GMU: DESIGN REVIEW COMMENTS – APPLICANT RESPONSE

Design review comments for Site 53, 2 Figtree Drive, Sydney Olympic Park – GMU Urban Design & Architecture

21 JUNE @ 1500

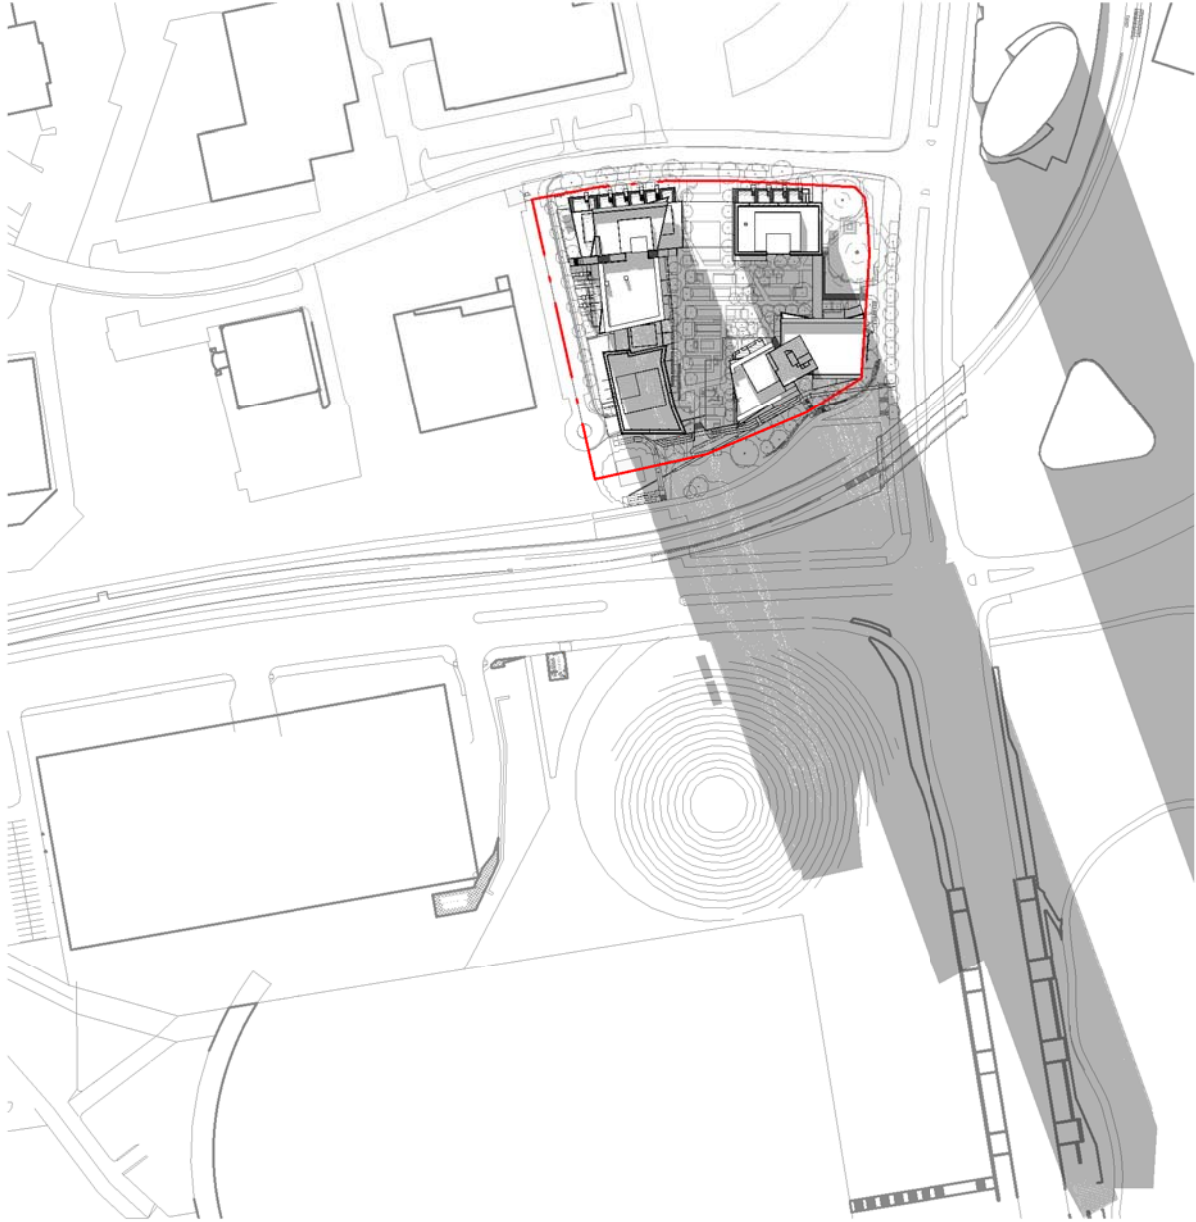
4. DAYLIGHT ACCESS The proposal does not satisfy the ADG's solar requirements. It relies on extended hours (i.e. 8am to 4pm rather than 9am to 3pm) to meet the ADG's minimum solar access requirement and exceeds the maximum percentage (15%) of units with no direct sunlight in mid-winter. The original winning 'alternate scheme' by BVN achieved 74% units receiving 2 hours of daylight between 9am to 3pm and only 6% of south facing single aspect units. In comparison, the quality of the performance of the proposal has declined in the current scheme. The use of extended hours might be reasonable if the context included significant impact from existing adjacent towers. However, as the site is not impacted to a meaningful degree by surrounding buildings, we do not consider the reliance on extended hours to be justified. Given that the site has a generous site area, frontages and a reasonable level of flexibility for configuration, the design should be able to achieve the ADG's requirements fully.	See discussion at Section 4.3.1 of the Report.
